**CITY OF ALBUQUERQUE
PLANNING DEPARTMENT
DECEMBER 29, 2004
DRB Comments**

PROJECT # 1003826

APPLICATION # 04-01905

RE: Tract 1-A, Levi Strauss & Company / Minor SPS

By: RM File: QCC SALES\DRAWINGS\SCHEMATIC DESIGN A2_ELEVATIONS	Sheet: 16 Of: A-1
--	-----------------------------

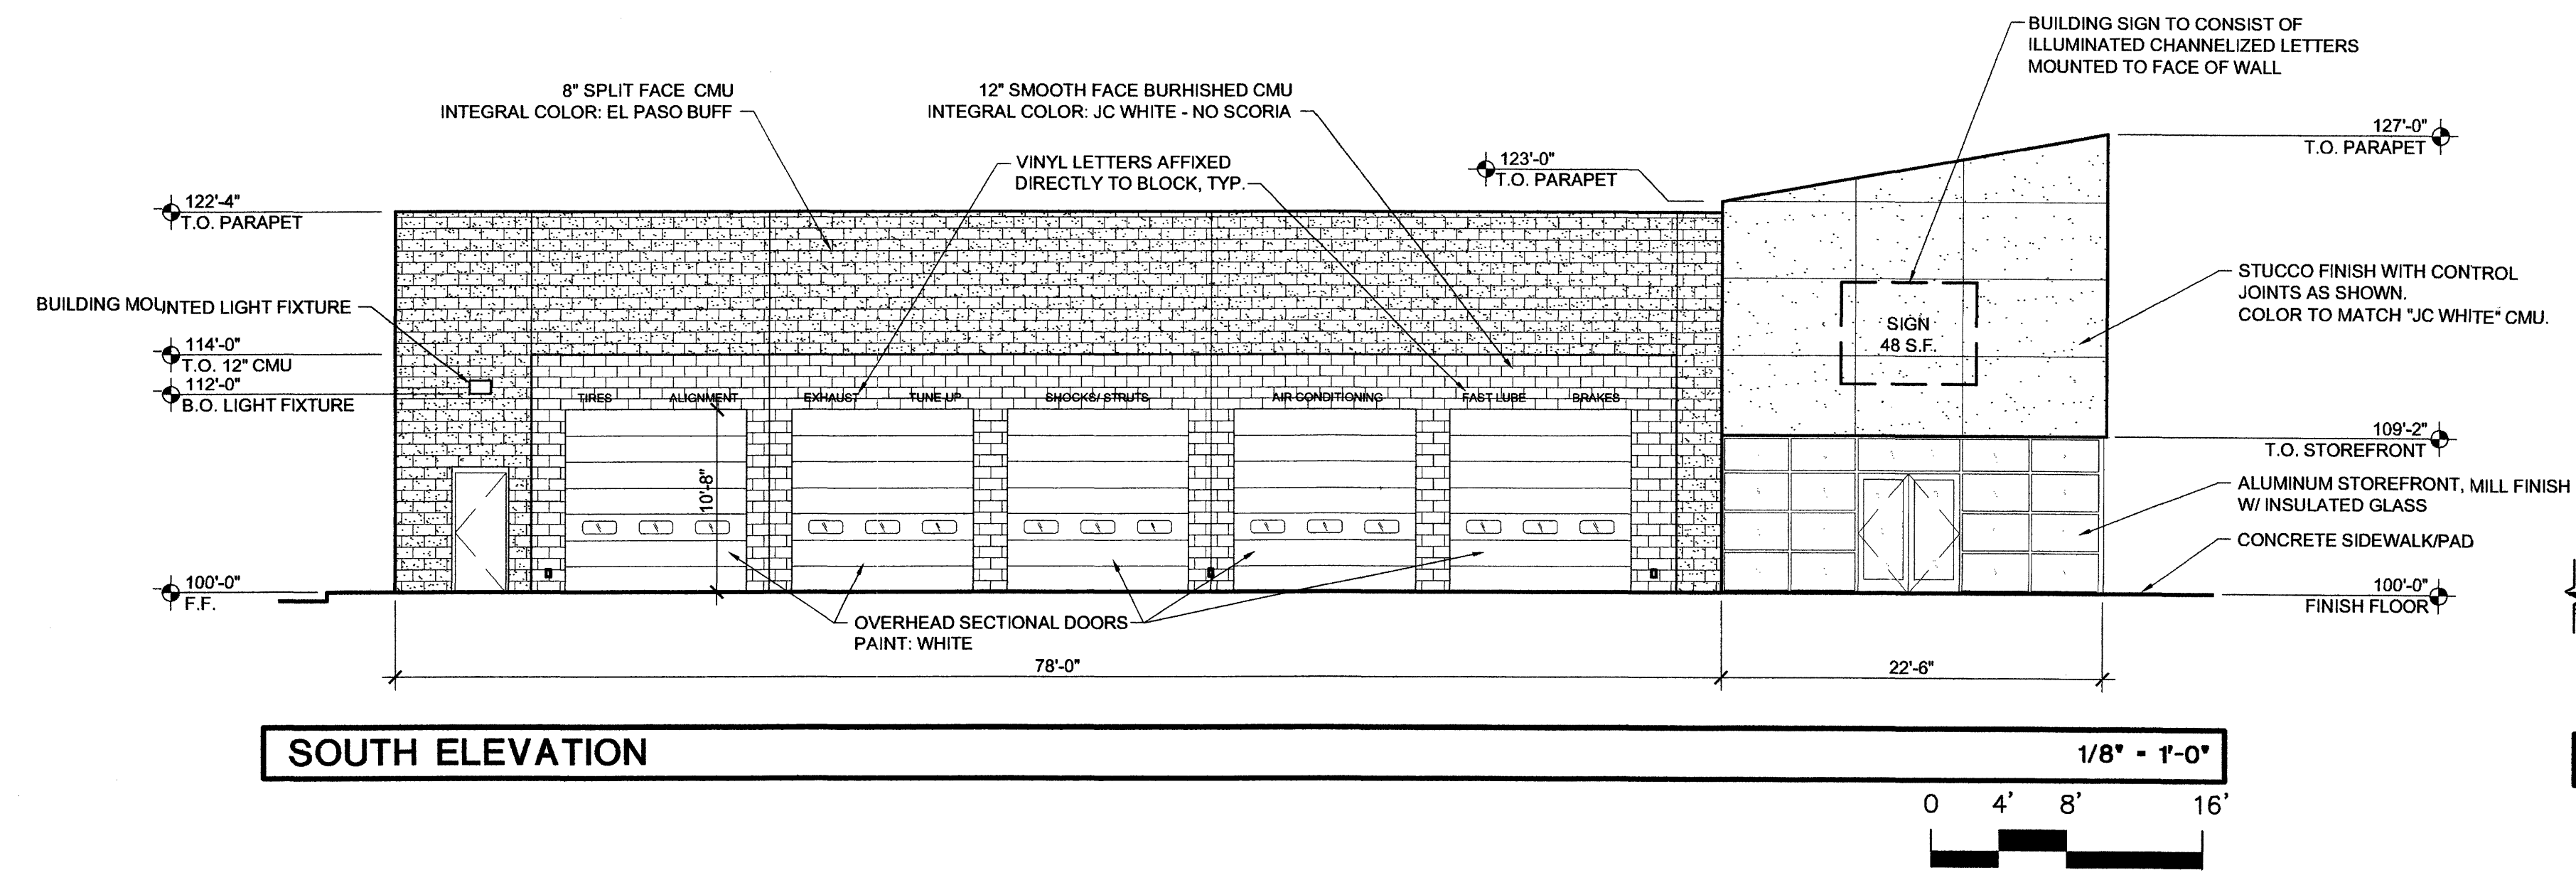
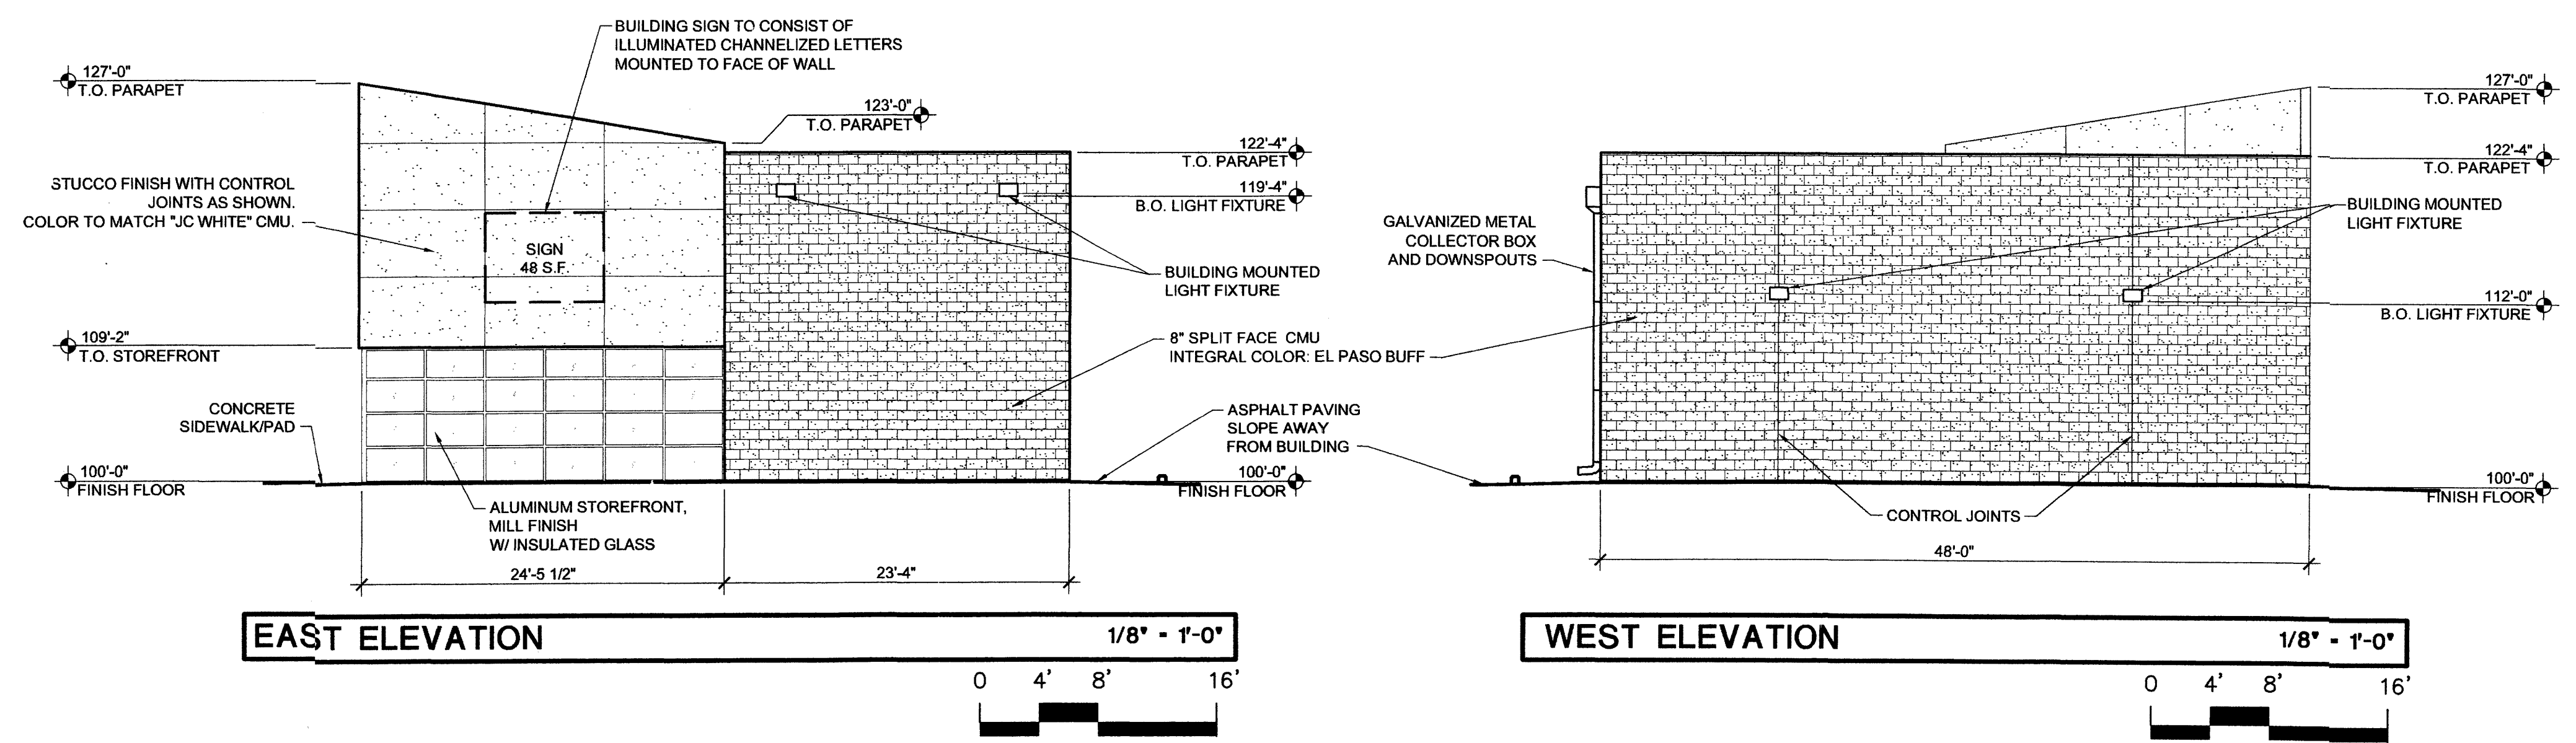
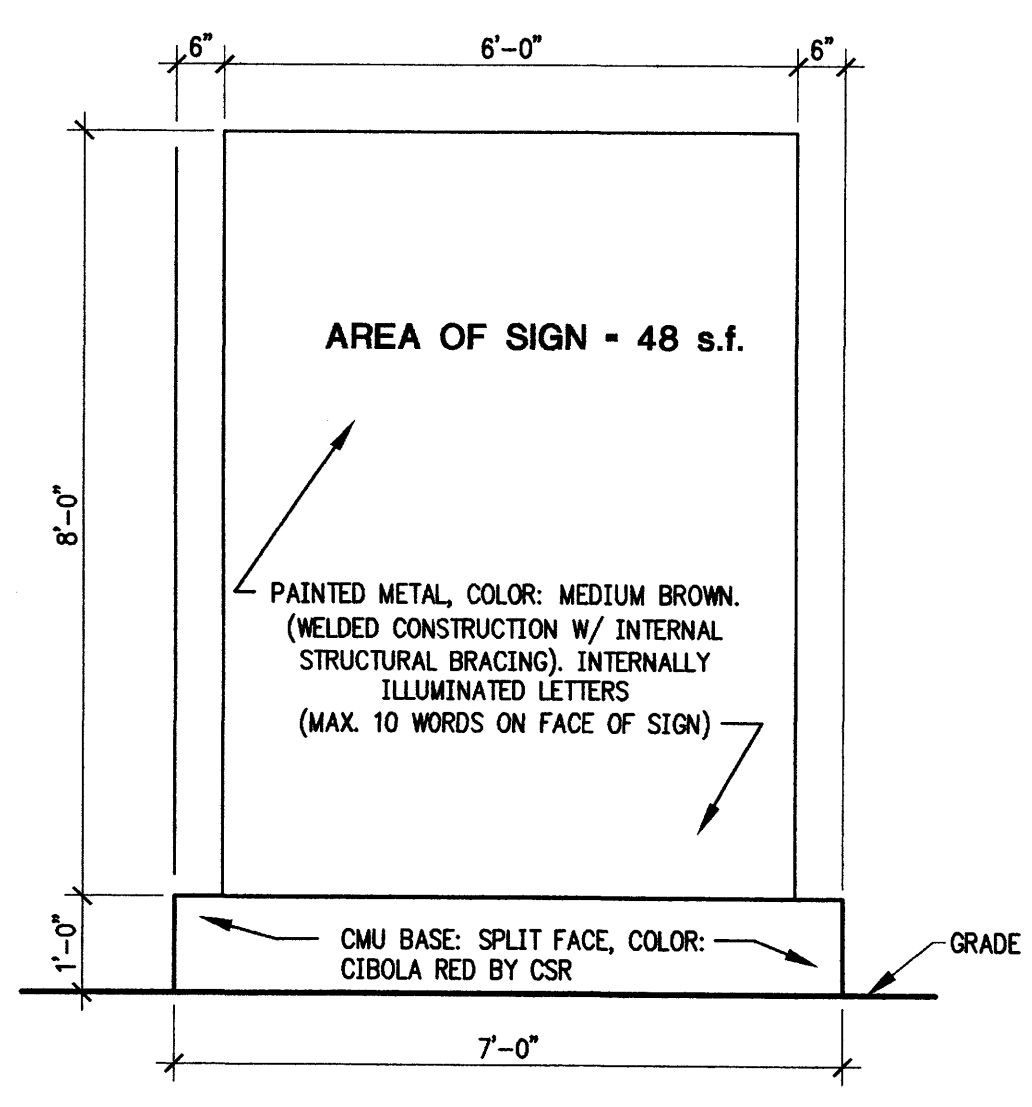
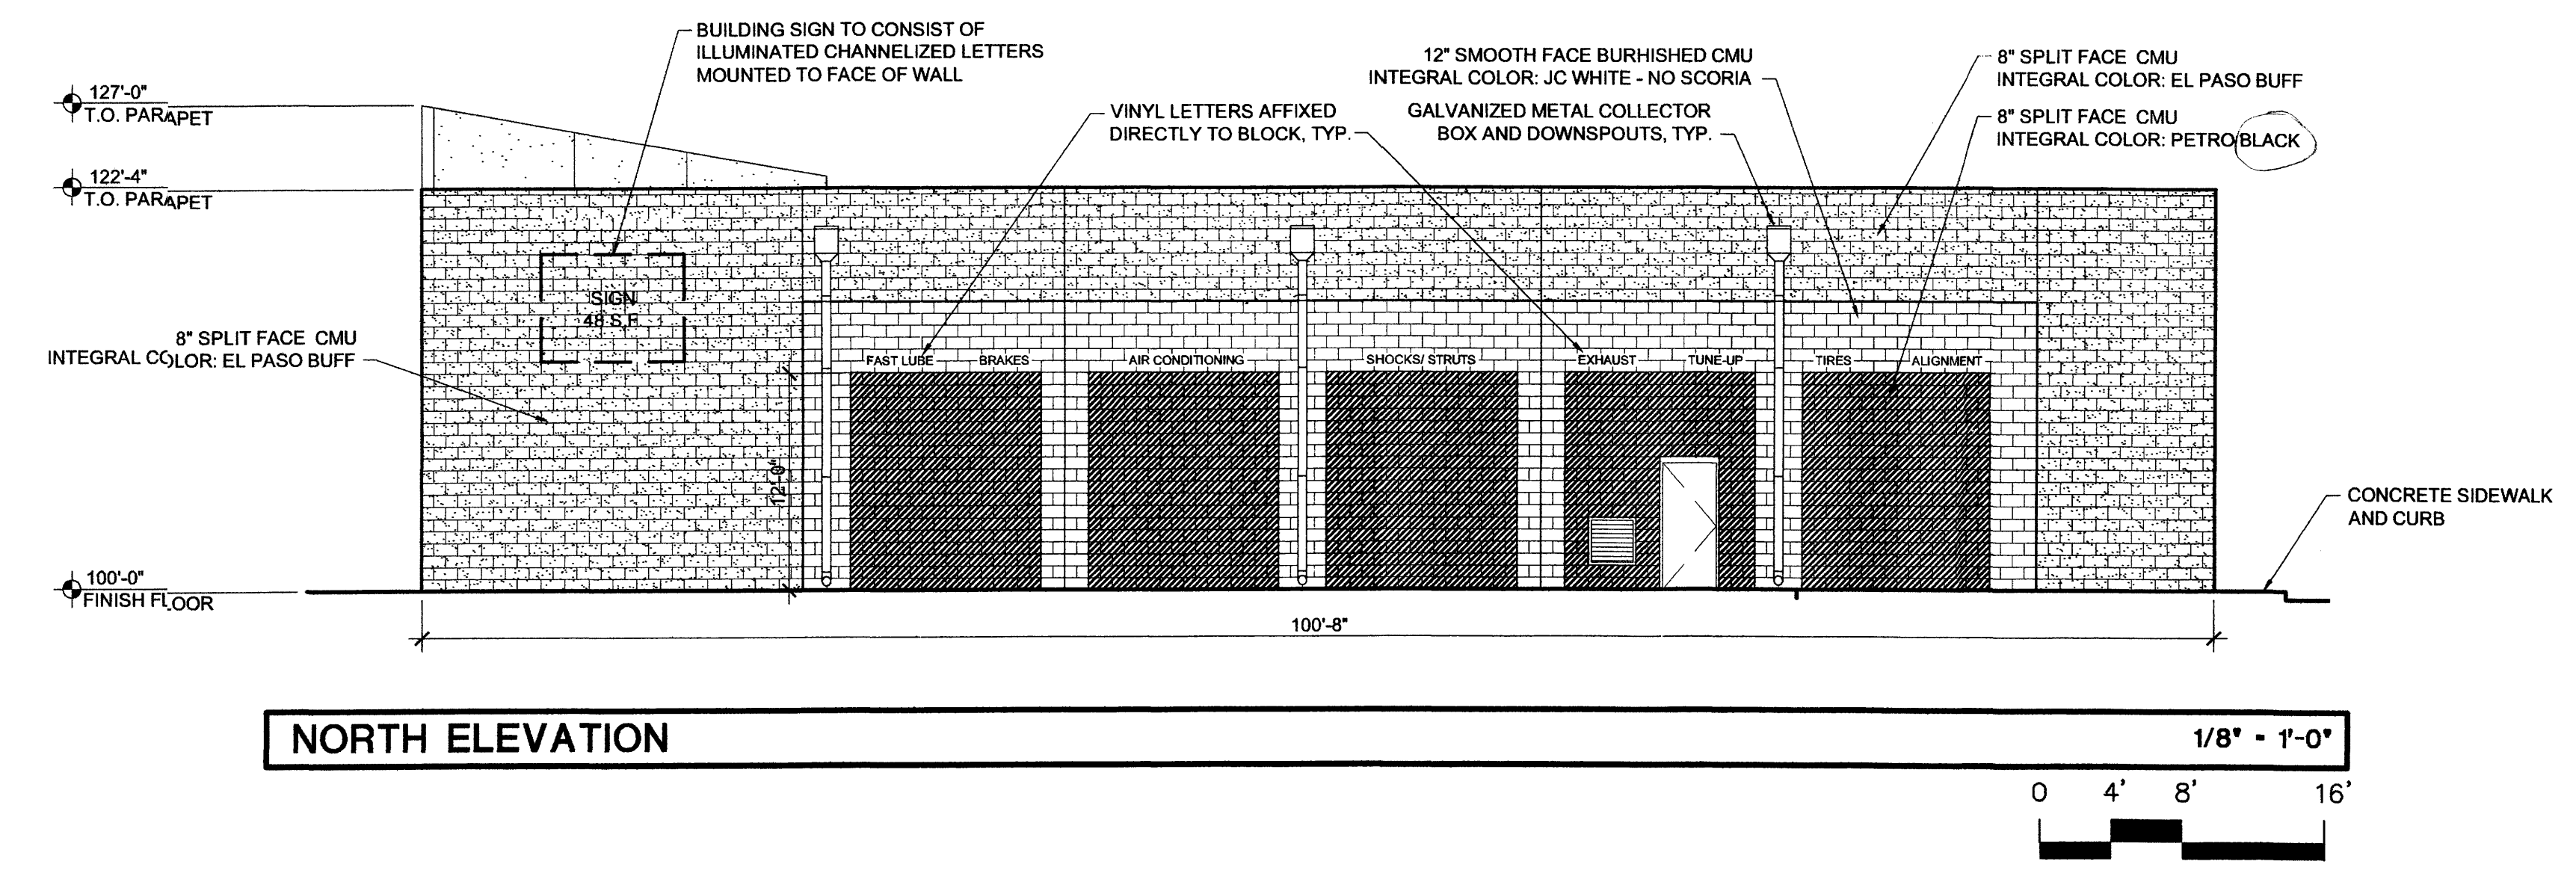
1. Label area south of Building 2 with regard to land use and surface material.
2. General Note G states that lighting details can be found on Sheet A-2. No lighting details are provided on Sheet A-2. Will all of the light poles be a maximum height of 18'? If so, provide a note to this effect.
3. Signs are regulated per the C-2 zone which only allows one monument sign on each street frontage. Applicant will be required to get a variance from the ZHE in order to have two monument signs along Alameda **or** remove one of the signs along Alameda.
4. The *Alameda Boulevard D.O.Z, Appendix A* lists appropriate species of plants that should be planted along Alameda Boulevard. At least 7 of the plants listed on the Landscape Plan will have to be replaced in order to comply with the landscape requirements of the *D.O.Z*.
